STIP No. A-0009CB

Concurrence Point 4B, Hydraulic Design Review Meeting Minutes

Purpose: The purpose of the meeting was to review and discuss the 30% drainage plans for STIP A-0009CB. The limits of the A-0009 CB Section are NC 143 from SR 1223 (Beech Creek Road) to 0.5 miles north of the Appalachian Trail.

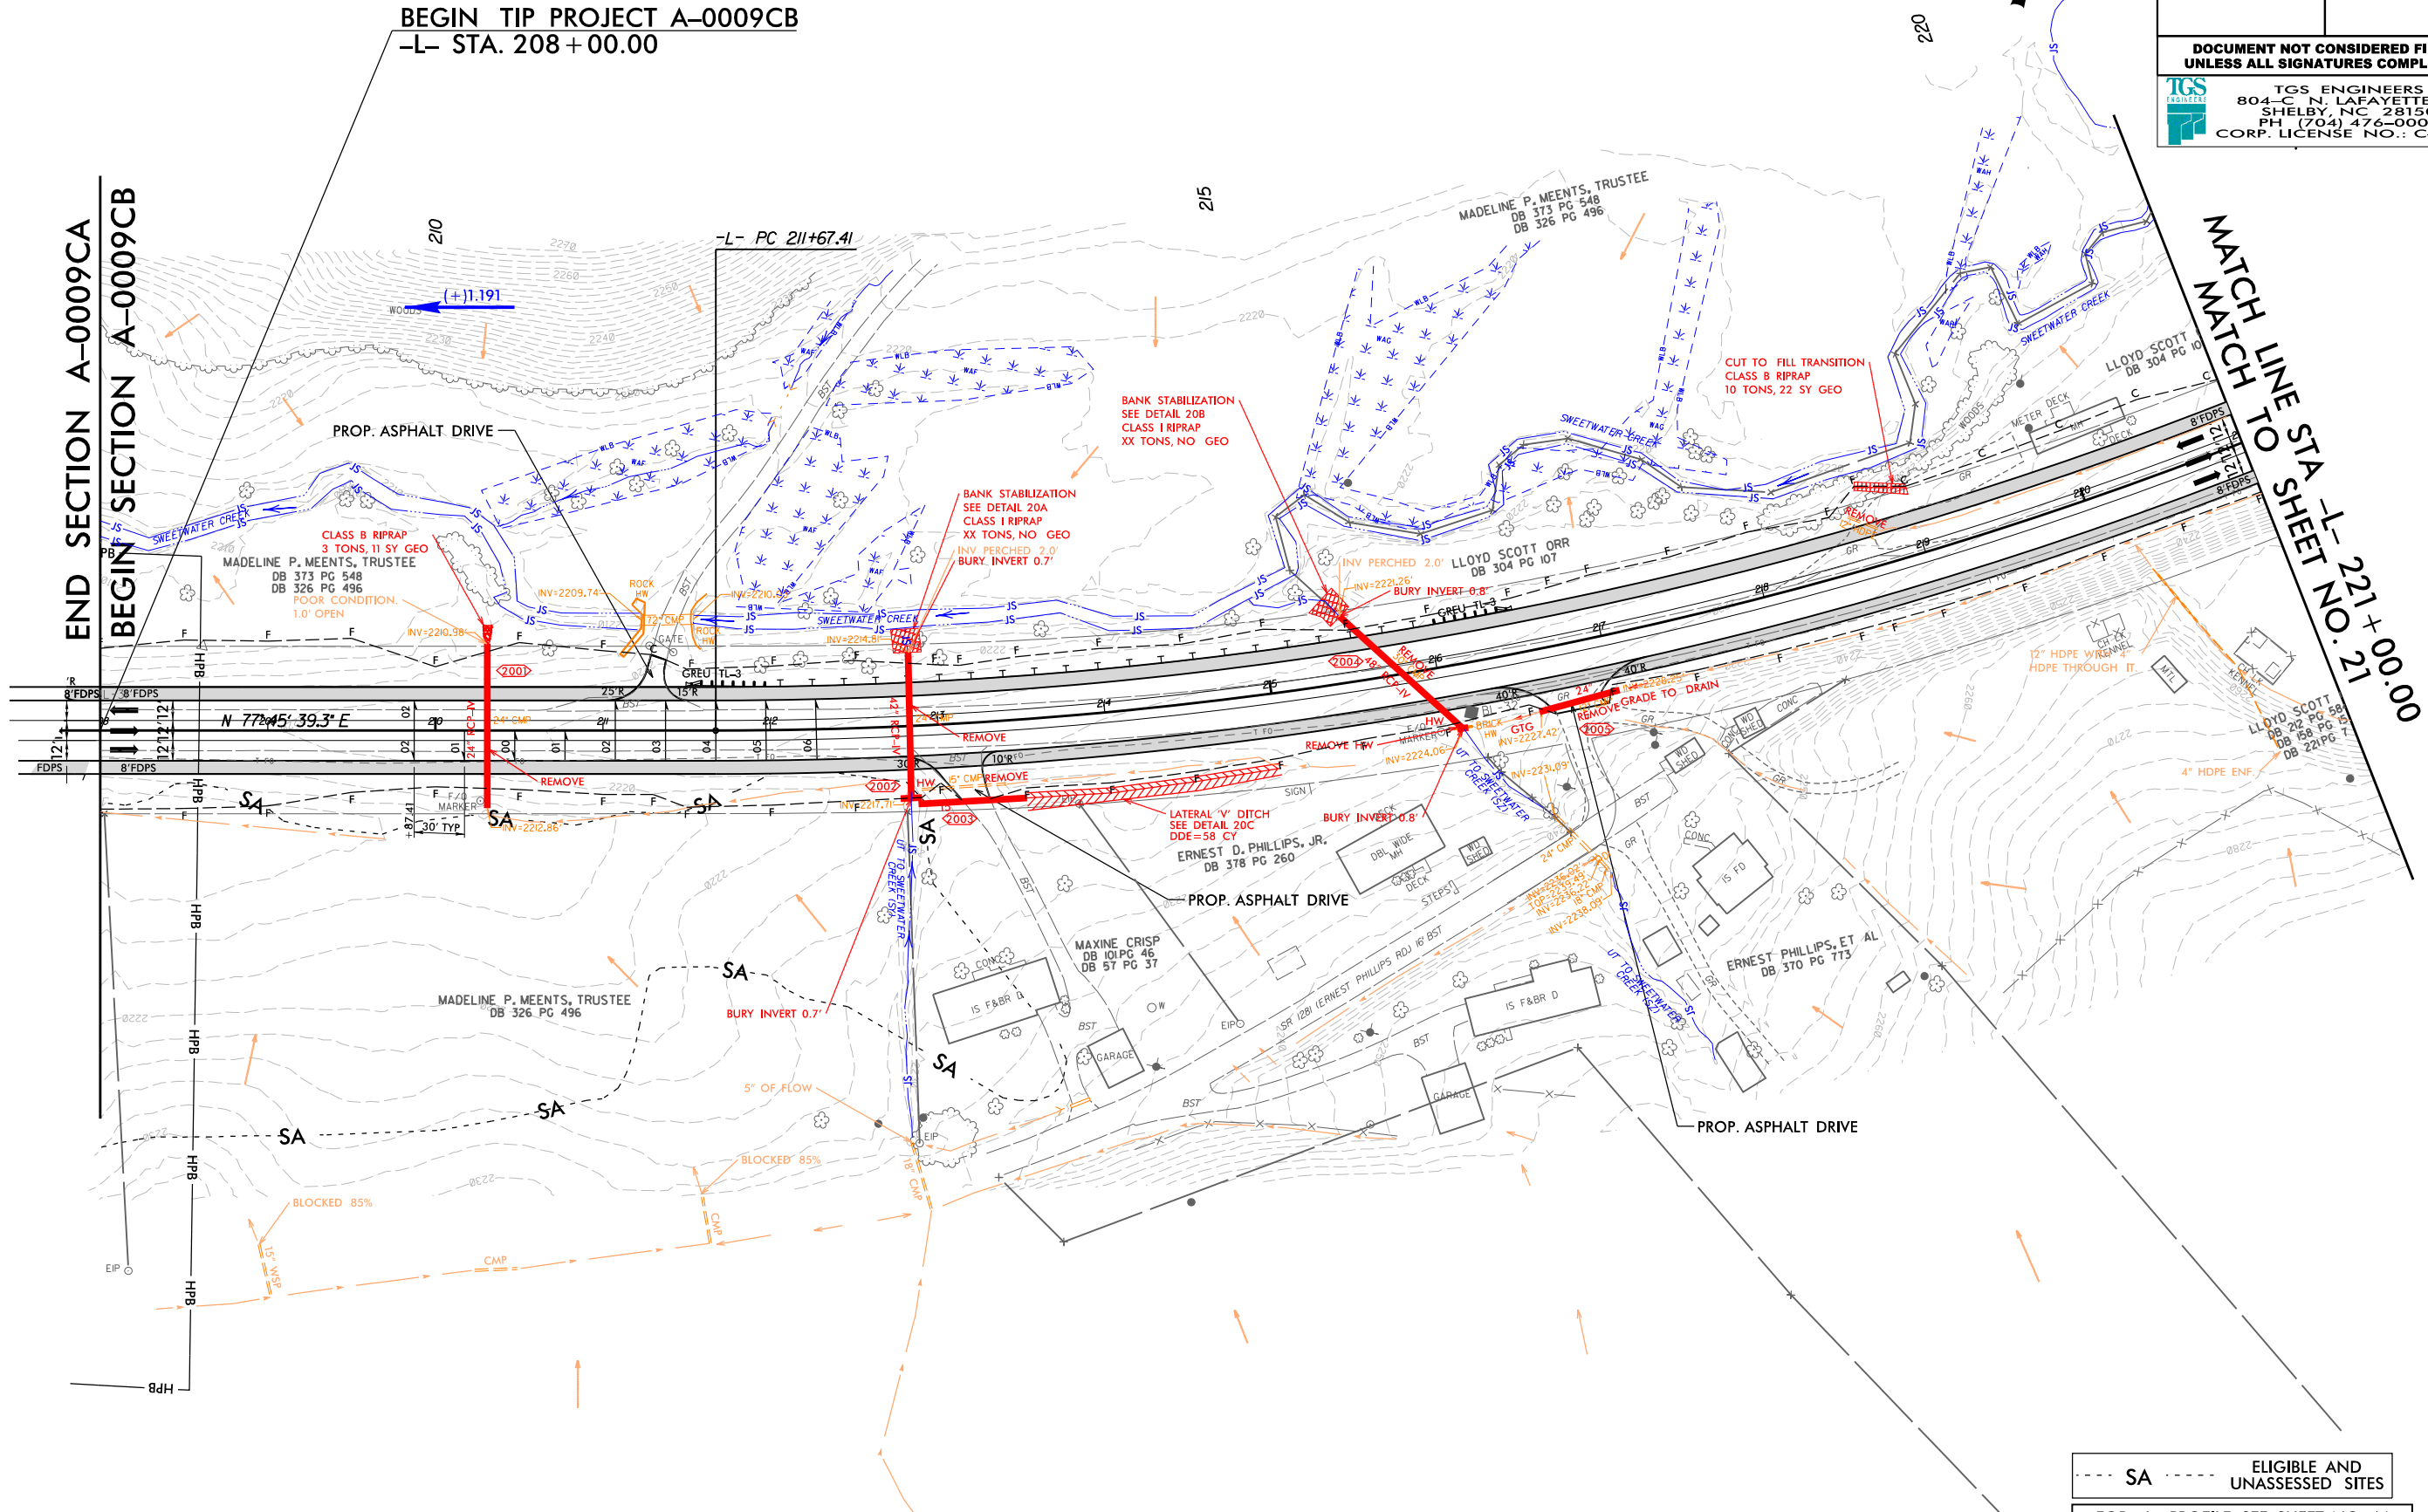
- Stream is approximately 3-4 feet wide on a 5-8% slope. The existing 24-inch CMP is perched 2-feet. A 42-inch RCP-IV on a 4.8% slope, buried 0.7-feet is proposed and Class I Rip-Rap outlet protection.

- NCWRC asked if the proposed was pipe large enough for fish (trout) passage and if fish are present in the stream. NCWRC suggested the use of stepped pipes or a wider culvert to allow stream to meander with alternating baffles and utilizing a 3% slope. NCWRC will meet internally with biologist and/or fish expert to see if any of the streams could be improved for better fish passage.

- TGS responded that the stream is identified as trout on the PJD. TGS stated that the proposed slope matches the natural gradient of the stream.
 - NCWRC affirmed but stated without pools which trout are known to use to get to the next step up. NCWRC asked that TGS design the crossing to make the stream as flat as possible.

- USACE asked if it was possible to up size outlet 2002 and add baffles.
 - TGS responded that it is not NCDOT standard practice to use sills or baffles in a small pipe.

- USACE stated that they appreciate the Team trying to maintain the existing slope but suggested that someone go to the area and look for fish.
 - NCDOT will investigate as requested but stated that fish would likely not be present.

- TGS stated that the existing pipe is perched 2-feet and the proposal has the pipe increasing by 3 pipe sizes.
- USACE questioned if the proposed pipe was too wide for streambed.

- Stream is approximately 1-3 feet wide on a 6% slope. The existing 30-inch CMP perched 2-feet will be replaced by a 48-inch RCP-IV on a 4.9% grade with the inlet and outlet buried 0.8-feet. Class I Rip-Rap will be utilized for outlet protection.
- USACE stated that the proposed 4-foot pipe maybe a little wide for a 1.5 -2 foot stream.
 - TGS responded that the stream is basically 3-feet, and we are proposing to bury it, therefore, the pipe will match the stream width.
- USACE asked NCWRC if they would have the same concerns with the stream width.
 - NCWRC confirmed and stated that they will investigate the stream details further.

- TGS responded no. The proposed pipe size is good and will match the stream width when buried.

MATCH LINE STA -L- 235 + 00.00
MATCH TO SHEET NO. 21

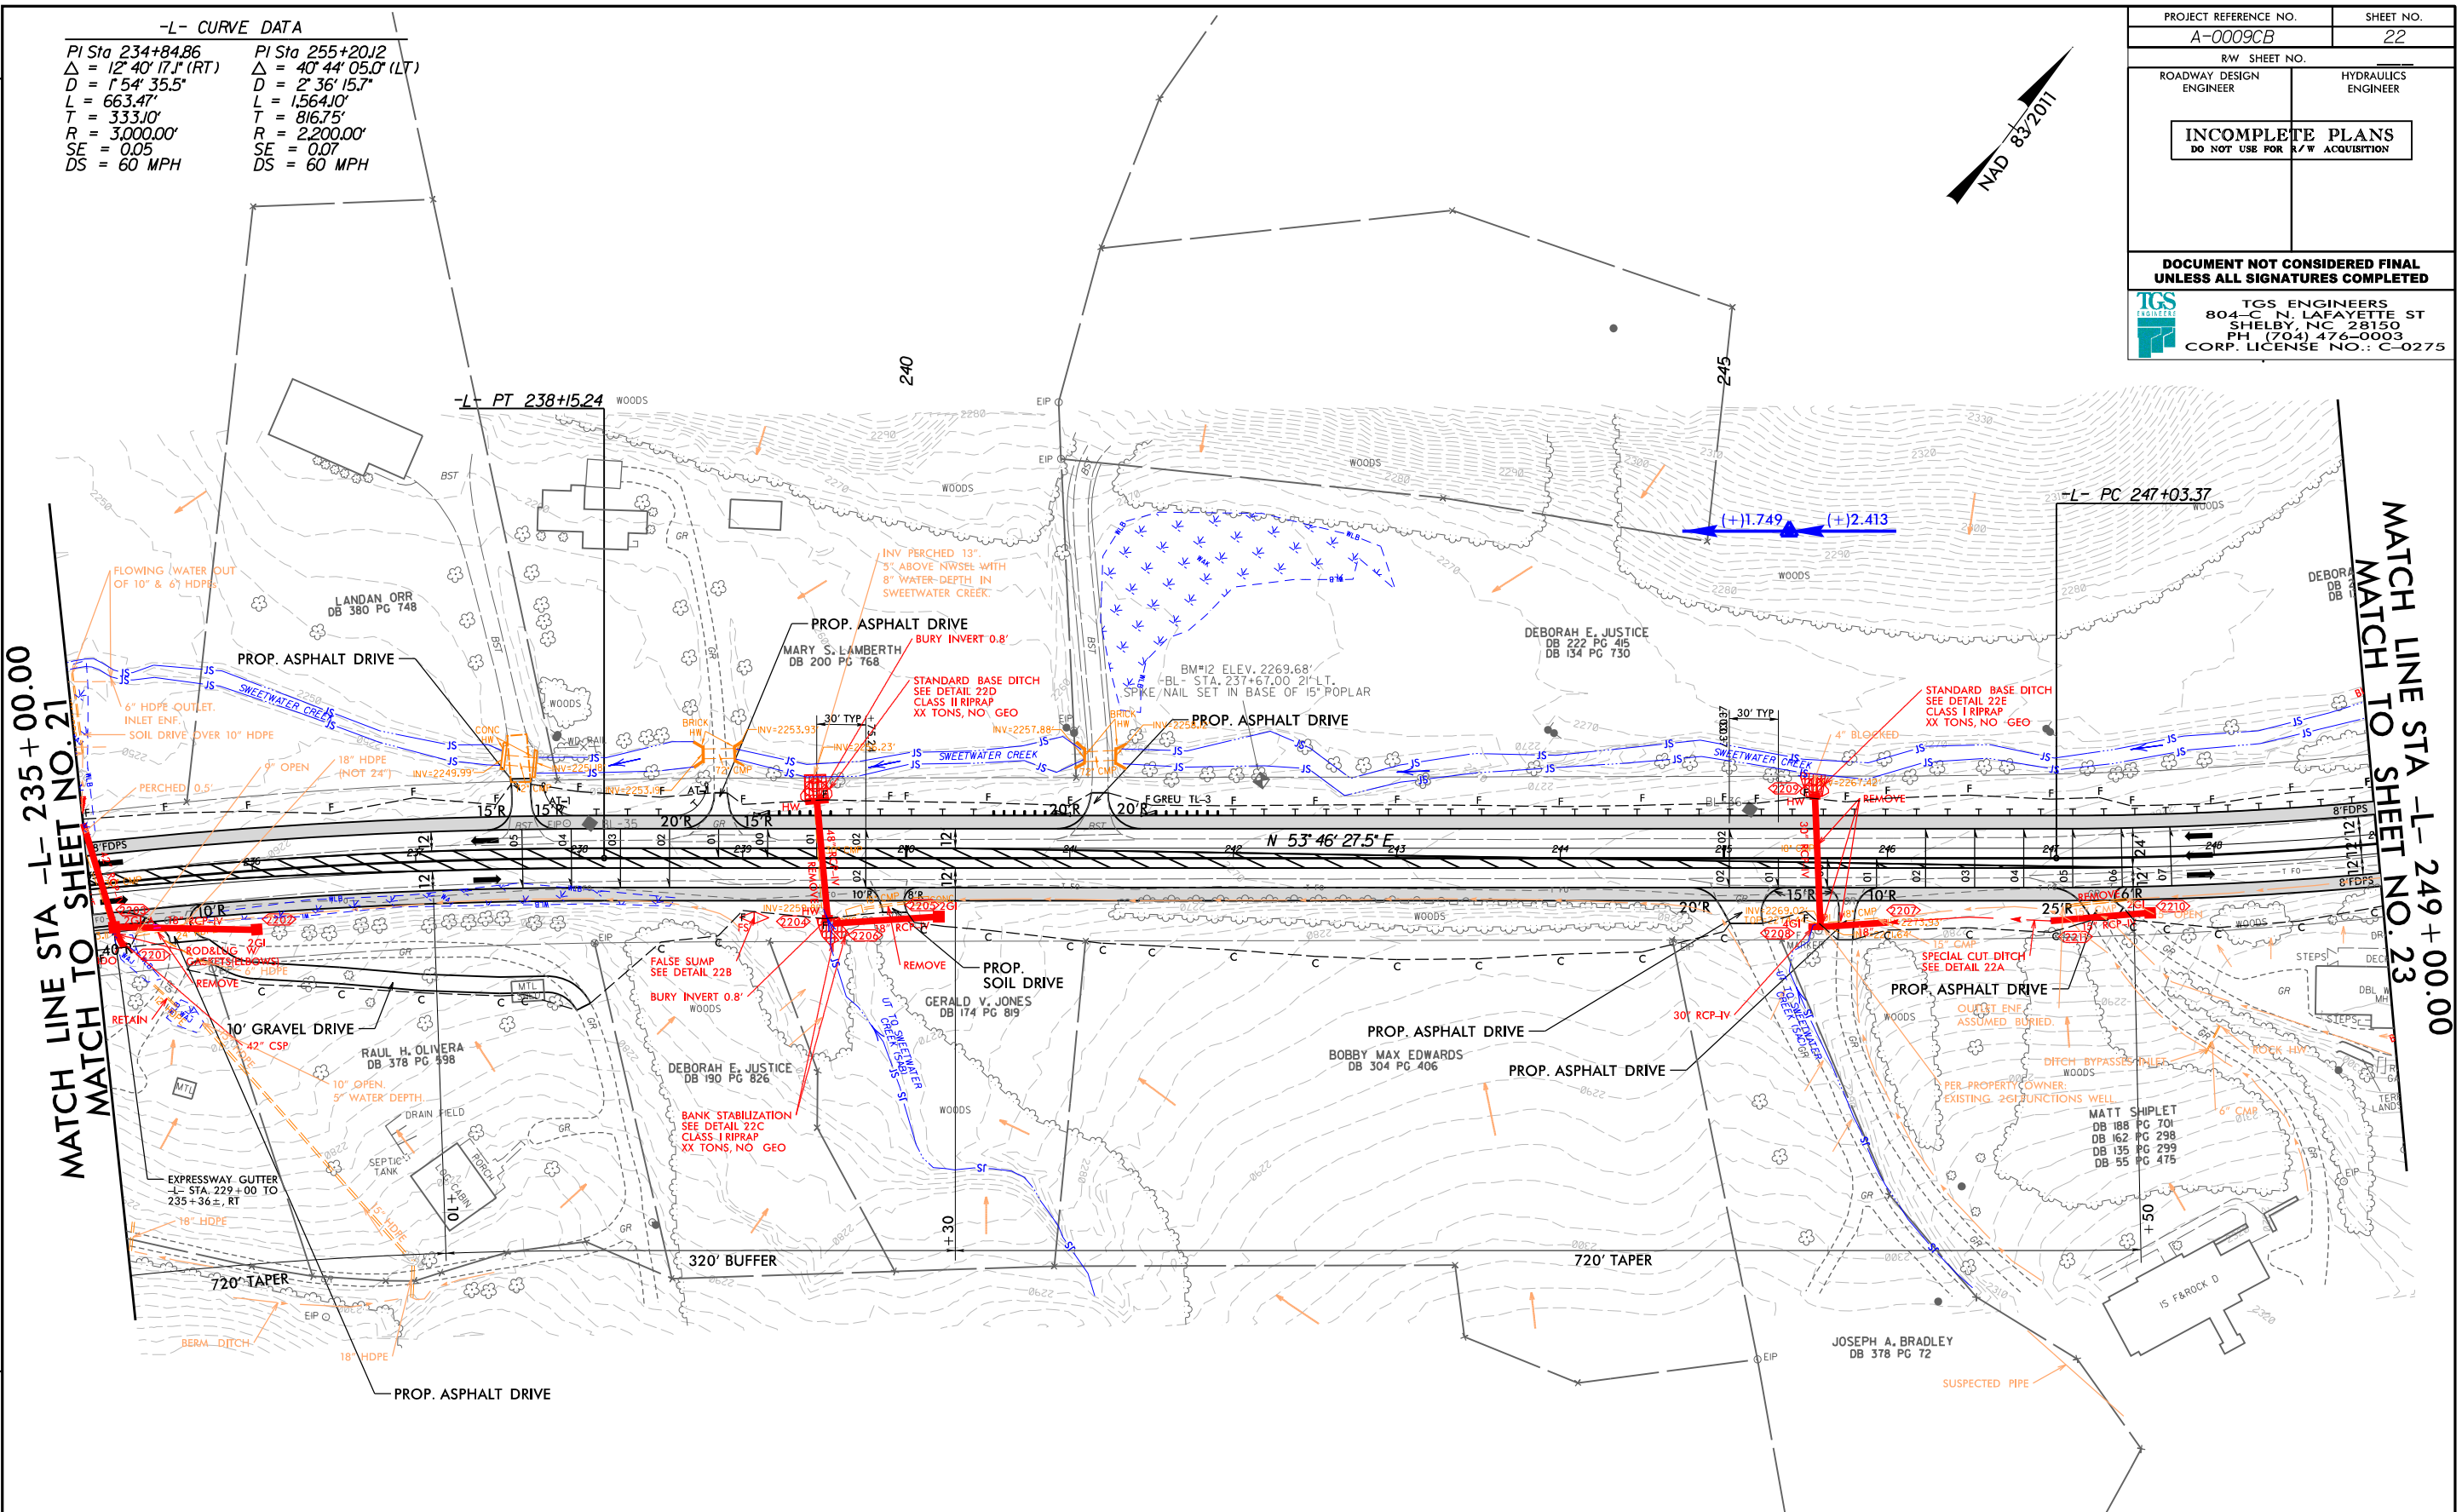
- Mostly under the proposed paved shoulder of proposed roadway improvements
- Unavoidable parallel impacts
- NCDWR requested that the system at the beginning of Sheet 22 (currently cut off) to be blown up on the 4C plans
 - TGS agreed.

- Stream is approximately 2-4 feet wide on an approximately 4% slope. The existing 30-inch CMP perched 1.1-feet will be replaced with a 48-inch RCP-IV on a 3% slope. Class I Rip-Rap will be utilized for bank stabilization.
- TGS will update stream Rip-Rap at outlet 2204 to match newly surveyed JS line
